C. Christian Berg, PE

February 6, 2020

Re: Lot 1 – 2434 Neills Creek Road
Lillington, NC

At your request, I have reviewed the plans proposed for new construction at this address. These plans were purchased from Frank Betz Associates and are entitled "The Foxcrofte". The architectural plans are dated 8/9/02, and the structural plans are dated 5/12/03. I reviewed the following sheets:

1 CORNICE DETAIL  
3/4" = 1'-0"

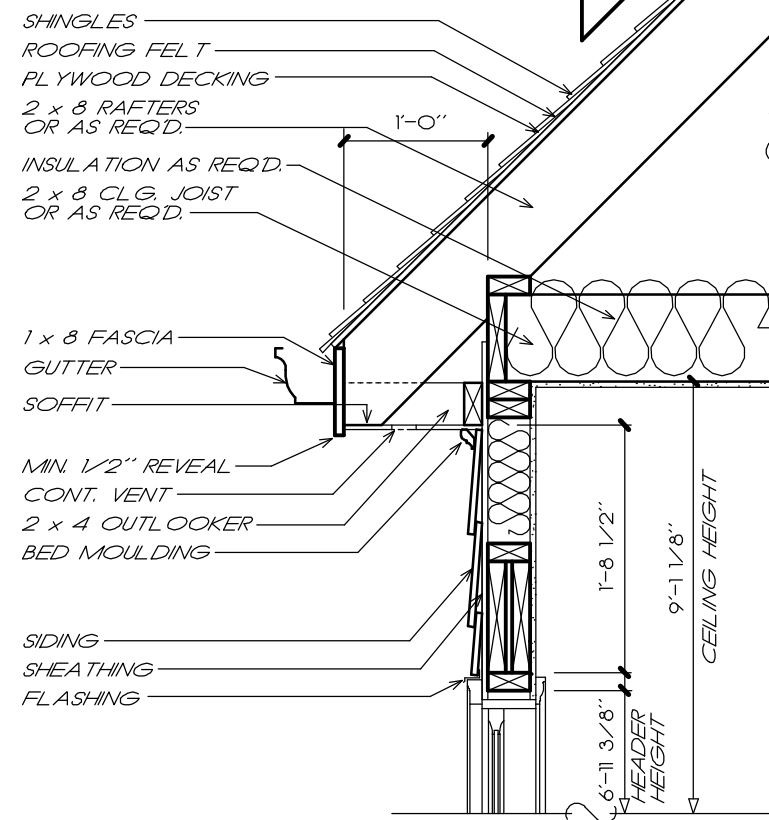
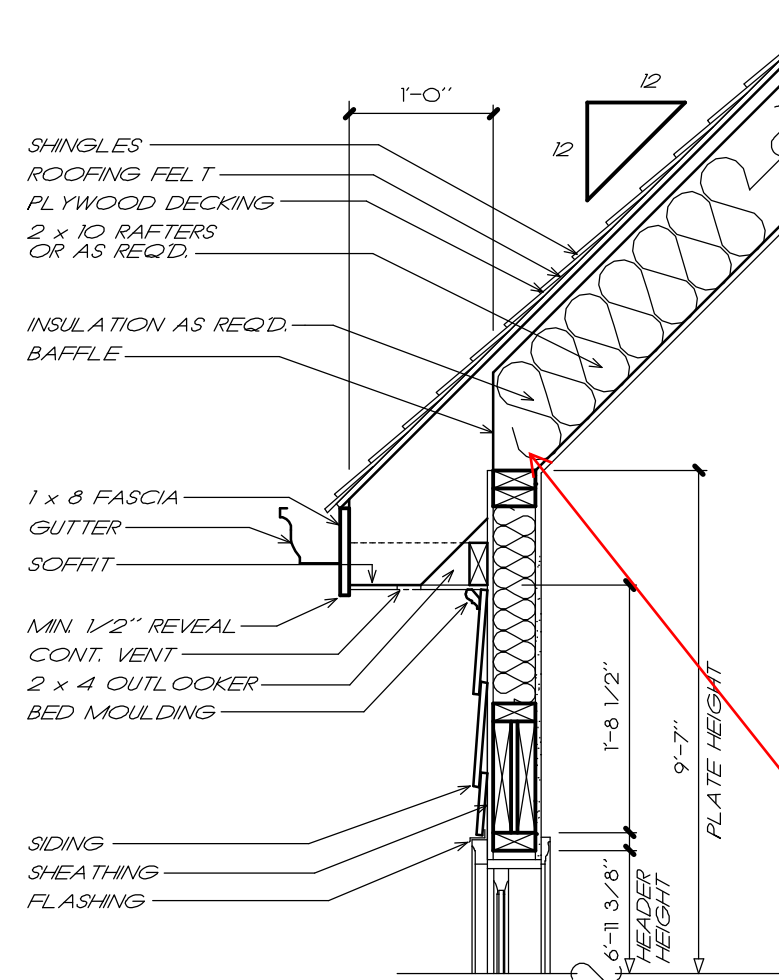
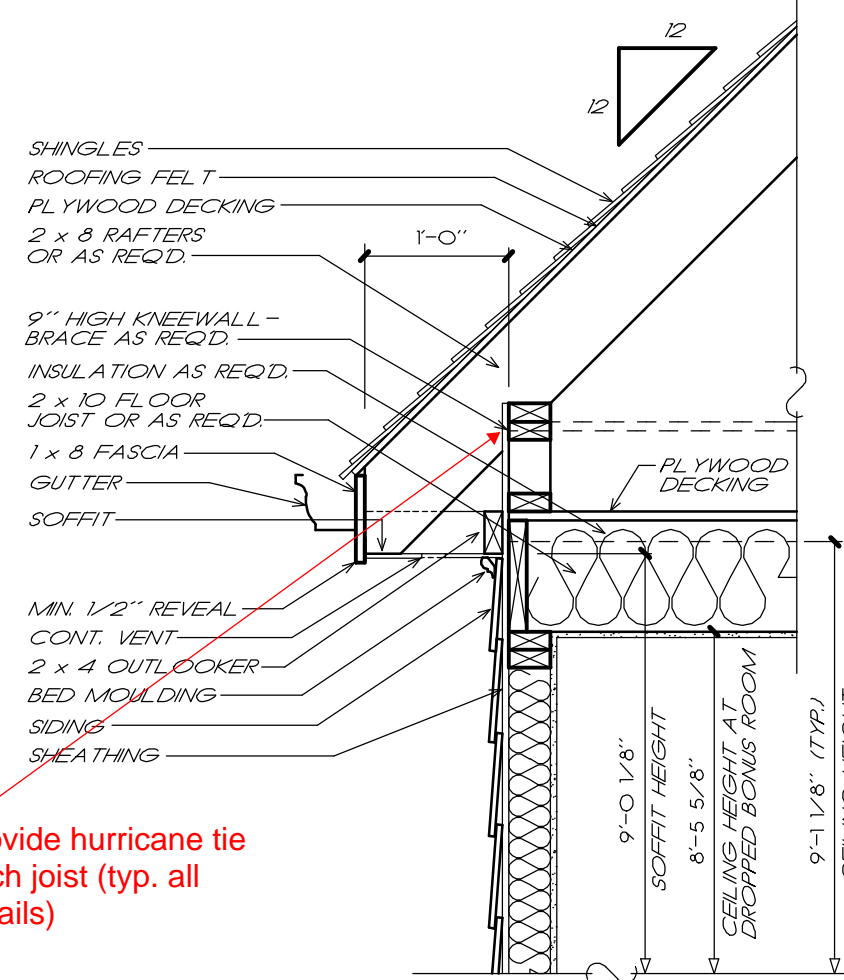
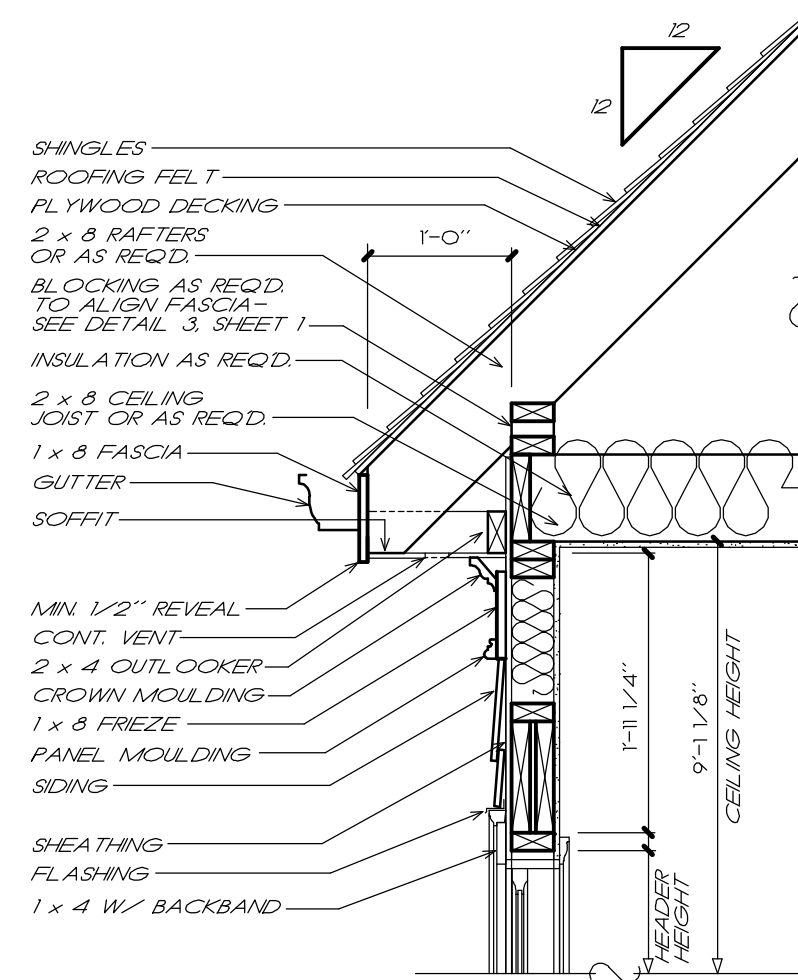
Provide hurricane tie each joist (typ. all details)

**CRAWL FOUNDATION PLAN**

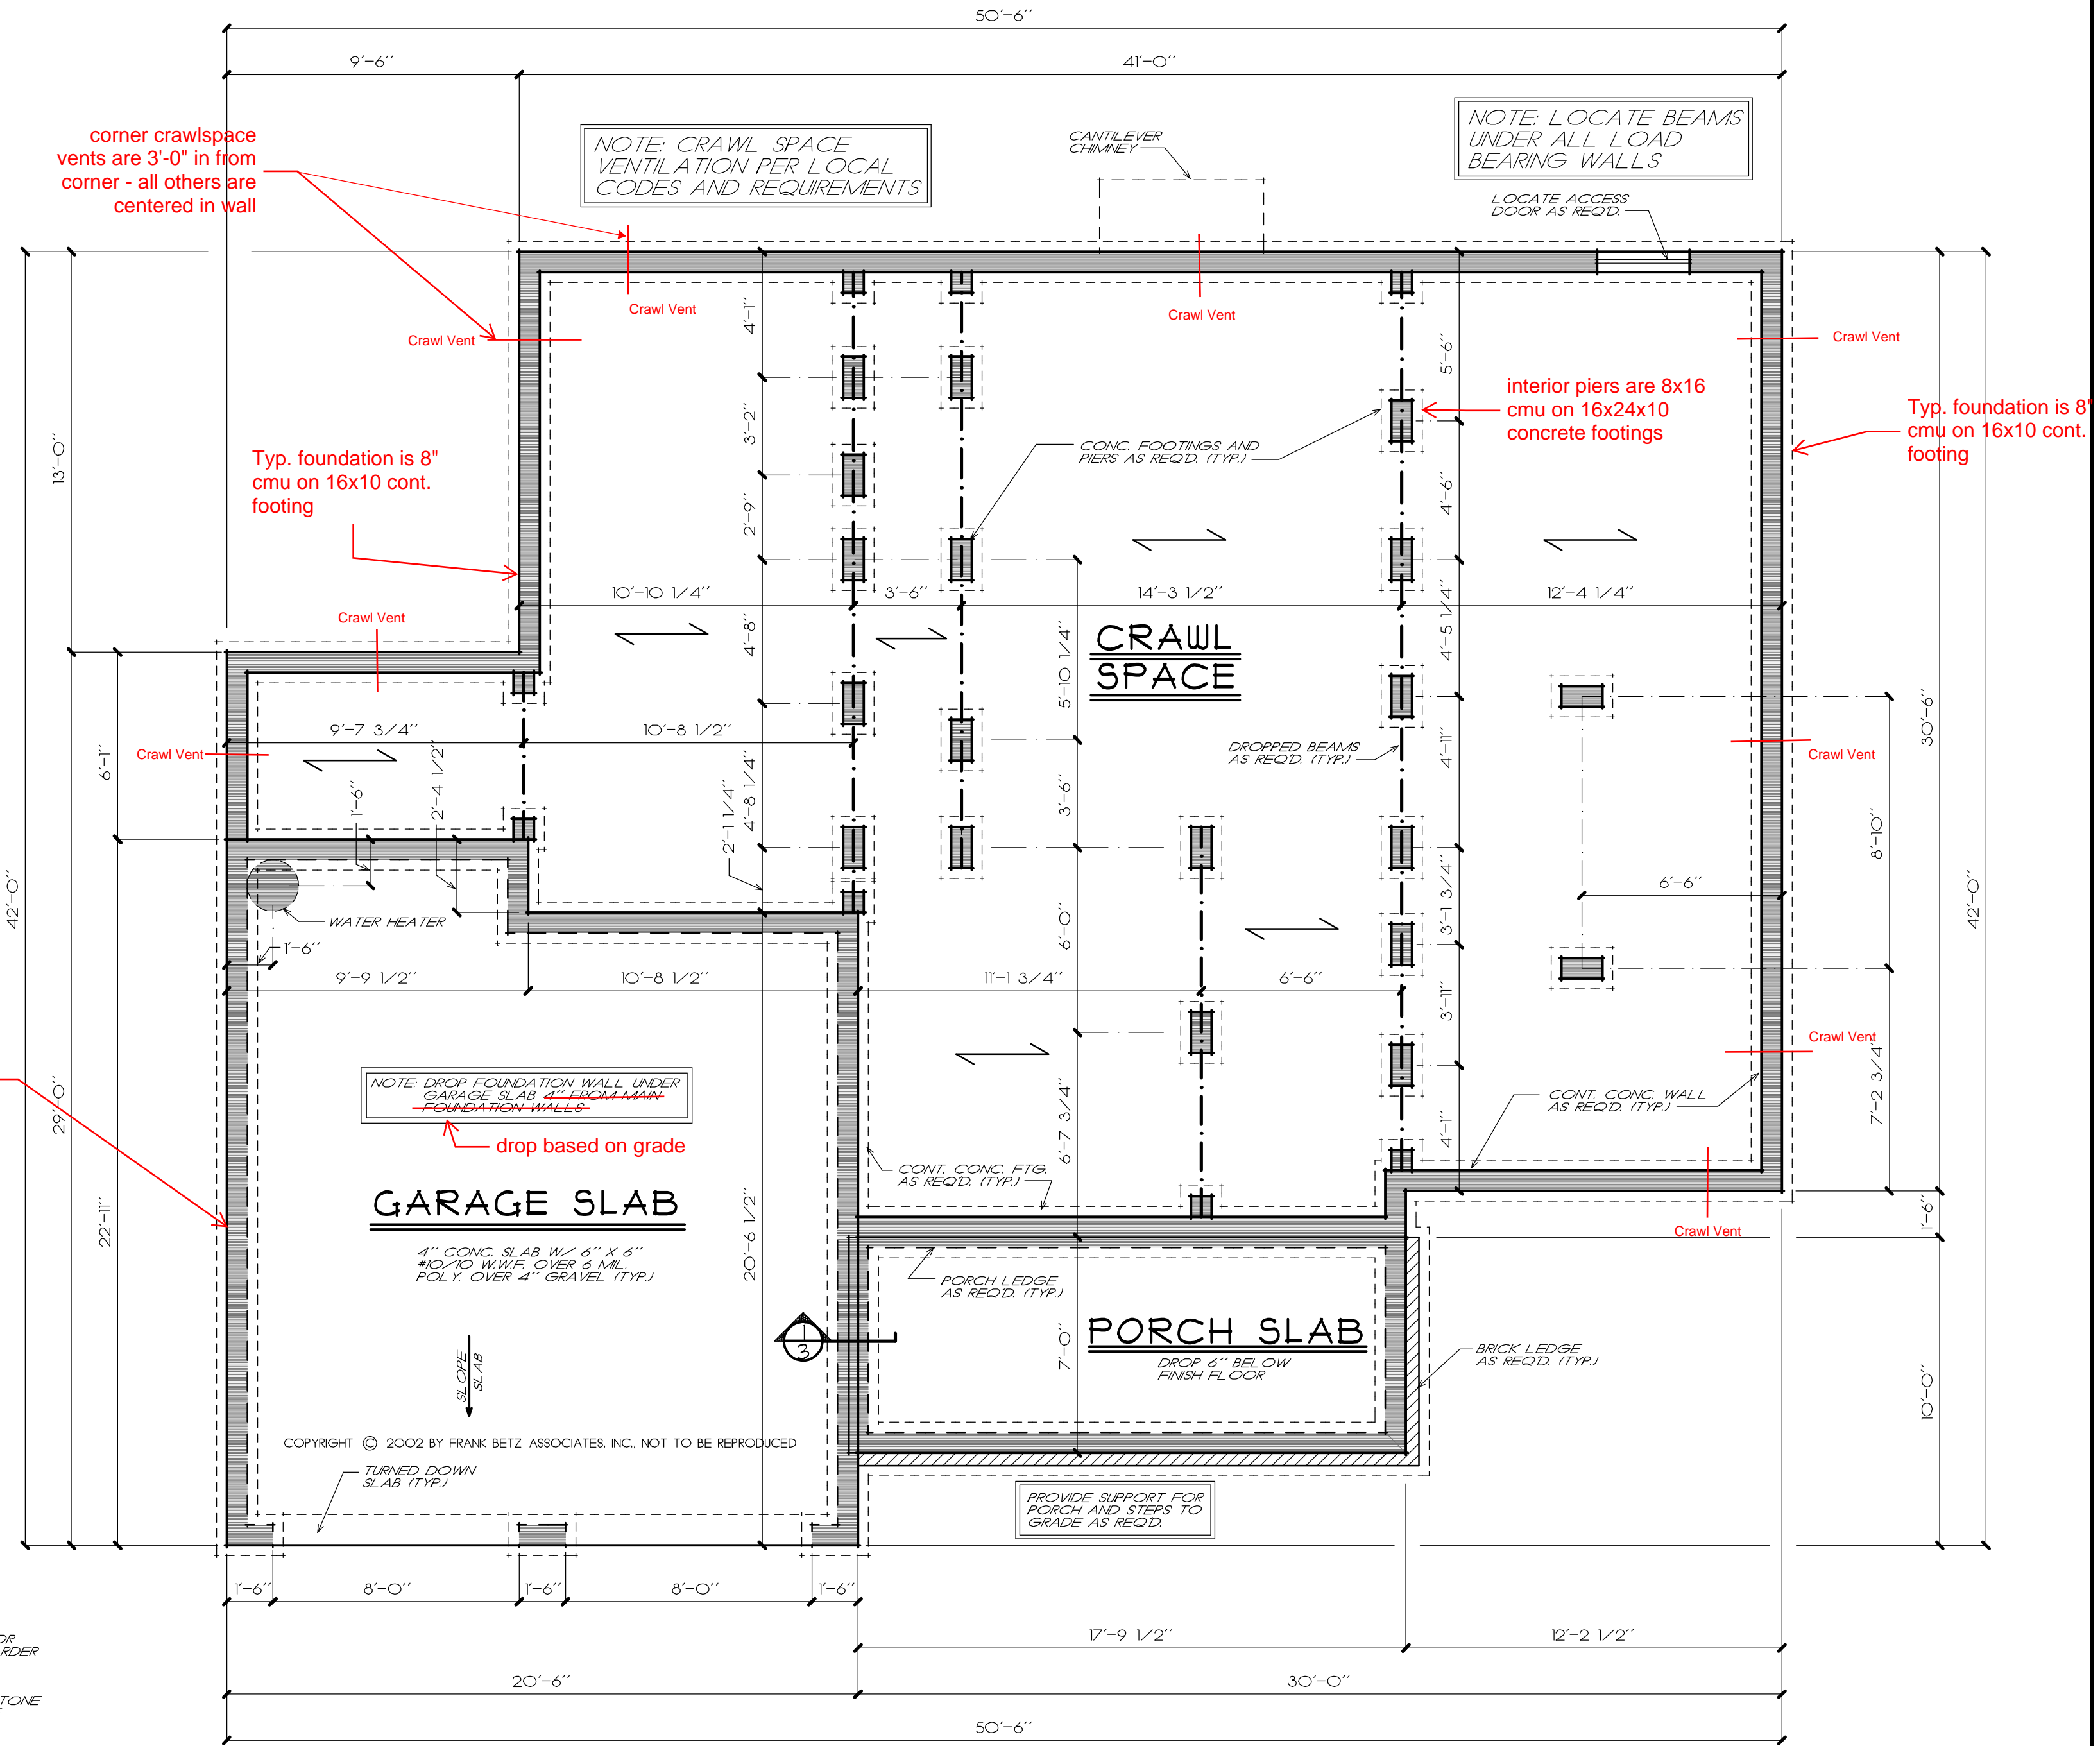
All footings bear at least 16" below grade

SHEET **F2**  
 OF 4

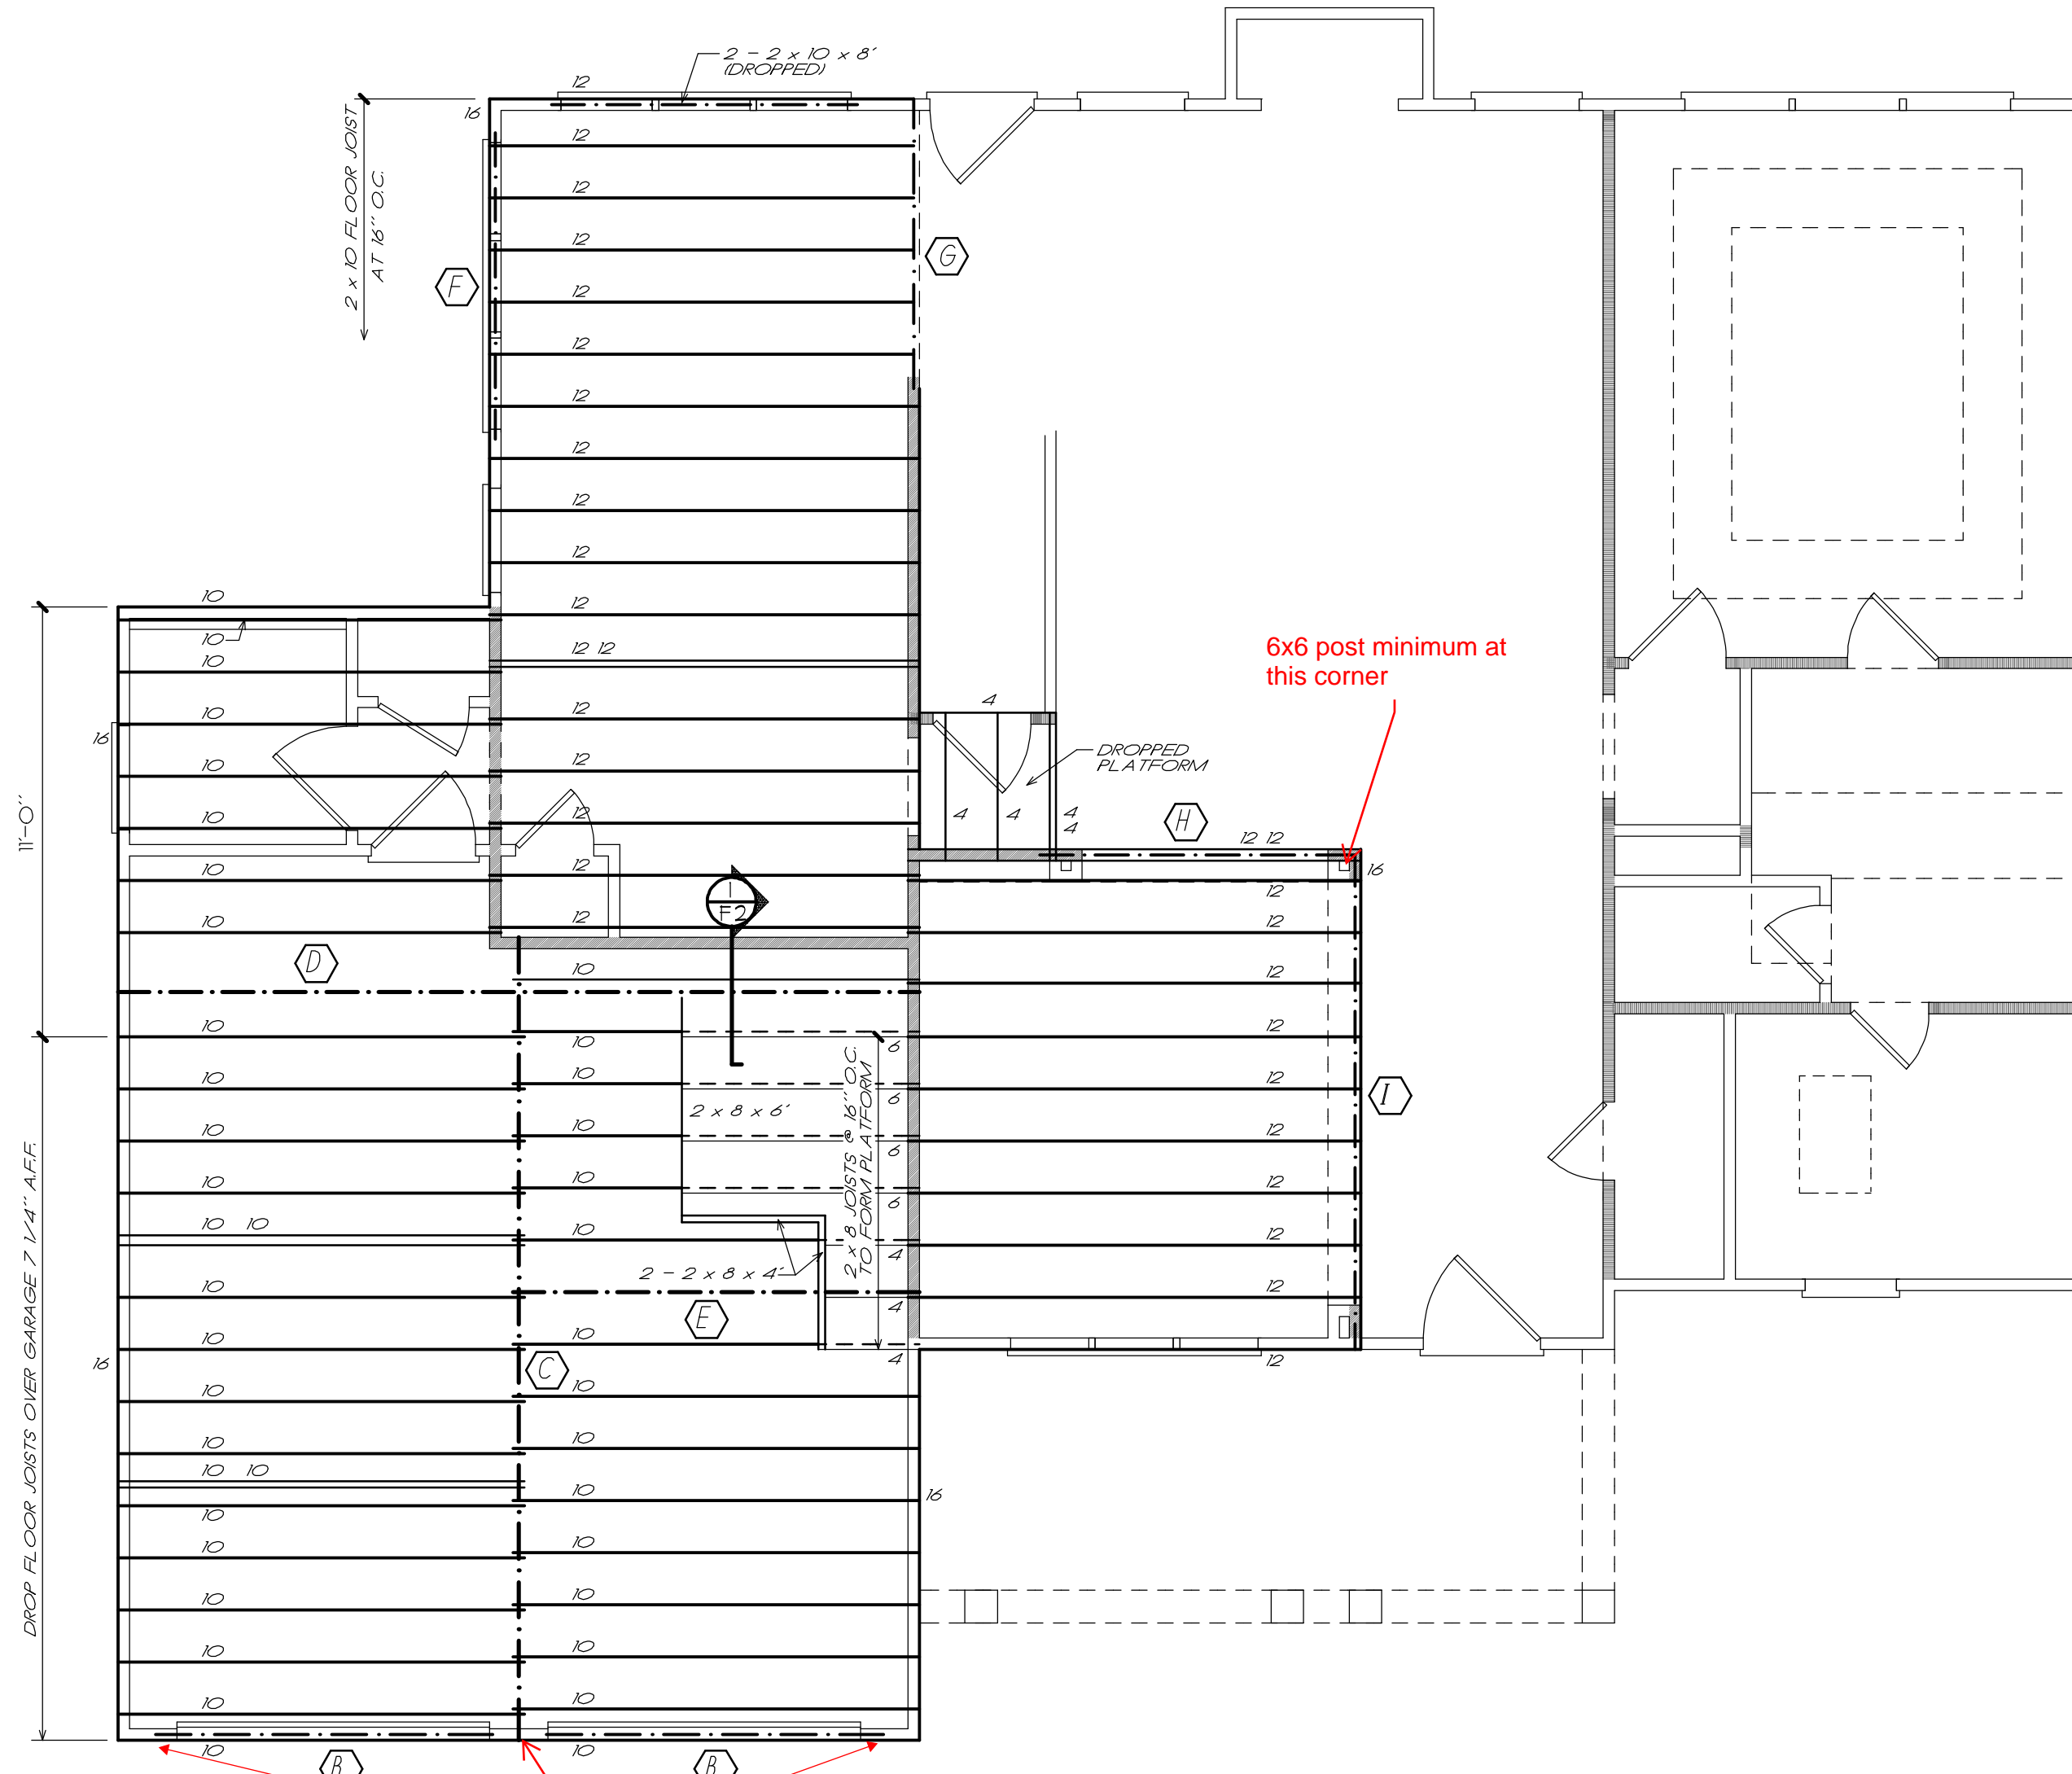
6x6 post minimum at this corner

this wall and headers constructed as portal frame per figure R602.10.1 in NC Residential Code
